HERBATA DATA CENTRE, NAAS - RESPONSE TO REQUEST FOR FURTHER INFORMATION ("RESPONSE TO RFI") FROM KILDARE COUNTY COUNCIL

ADDENDUM TO CHAPTER 1 INTRODUCTION AND NEED FOR EIAR

NI2615
01
June 2025

This Environmental Impact Assessment Report (EIAR) Addendum is provided in response of the Request for Further Information (RFI) from Kildare County Council (dated 4th October 2024) in respect of the proposed Herbata Data Centre Campus (the Project) which is subject of planning application reference 24/60787. The Kildare County Council RFI is provided in Volume II, Appendix 1.1.

DWG NO: 22217-RKD-ZZ-ZZ-DR-A-1400

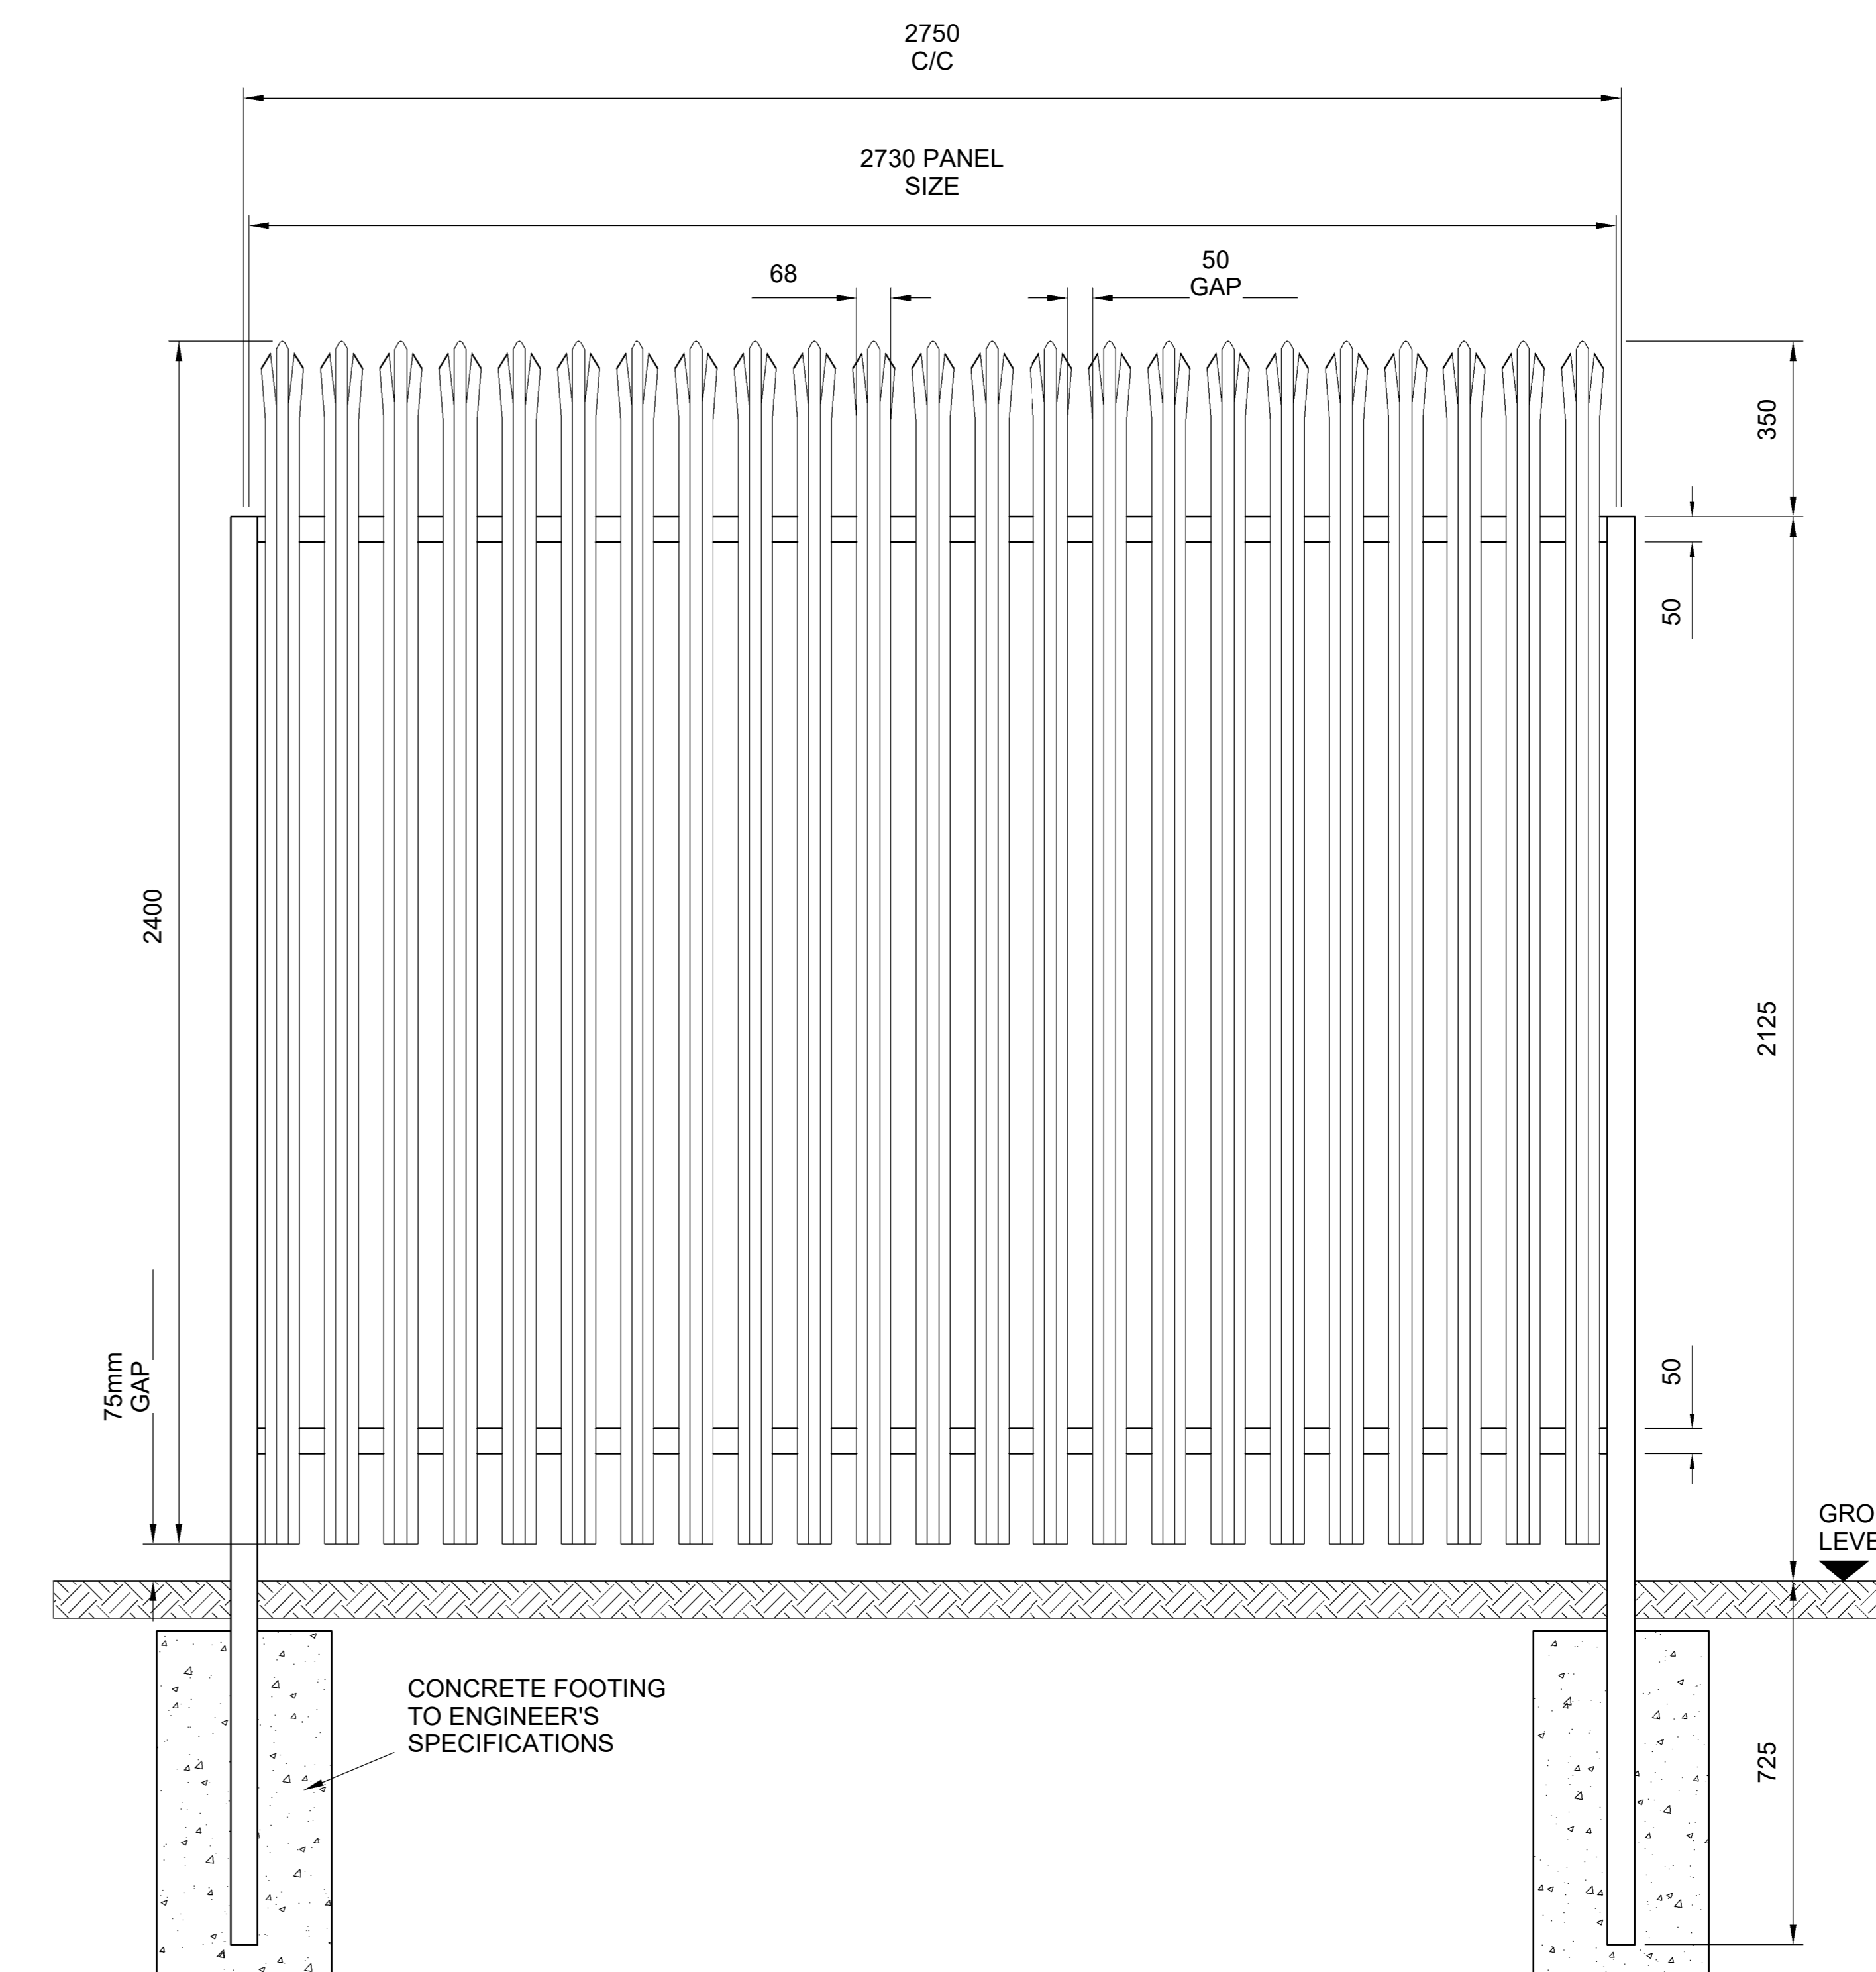
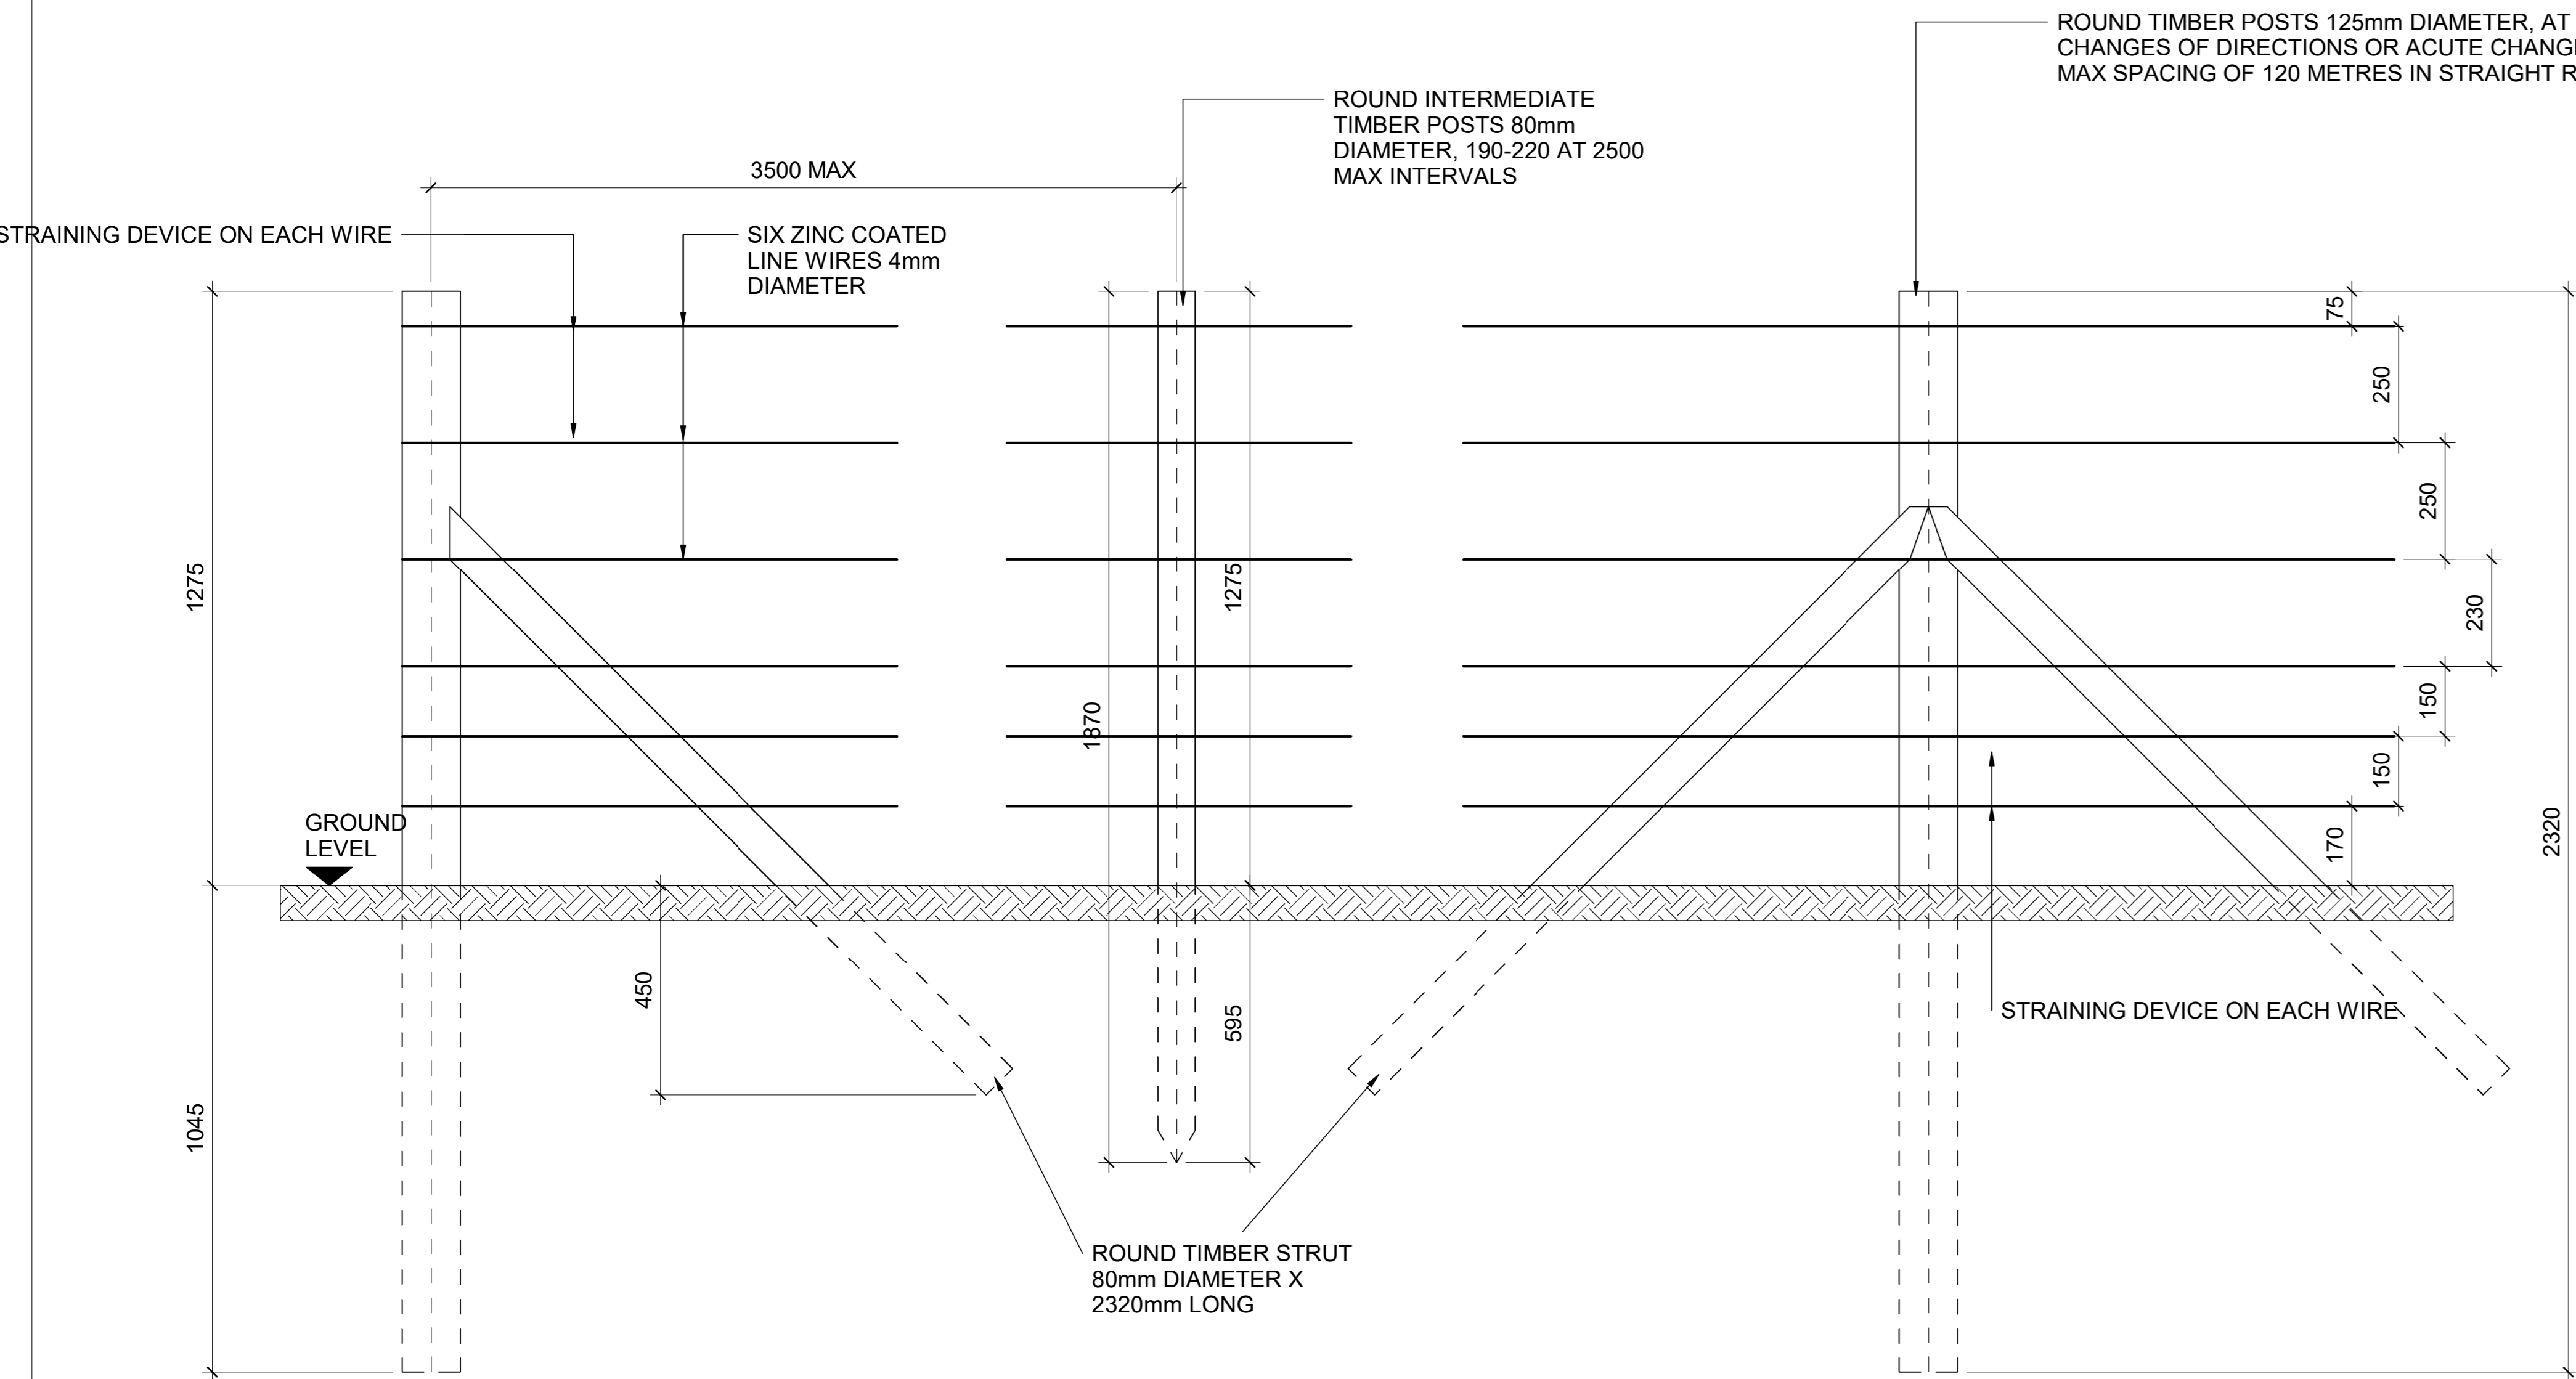
In response to the Kildare County Council RFI (Item 6) which notes the proliferation of palisade fencing throughout the site, an amendment has been made to the proposed Landscape Masterplan to include mammal passes in fences throughout the full extent of the site. These mammal passes are proposed within security fencing throughout the site, in order to facilitate movement of mammals across the site. There are no proposed amendments to the overall height, materials or layout of the proposed security fencing. Further detail and consideration of this is provided in the Addendum to Chapter 5 Biodiversity of the EIAR.
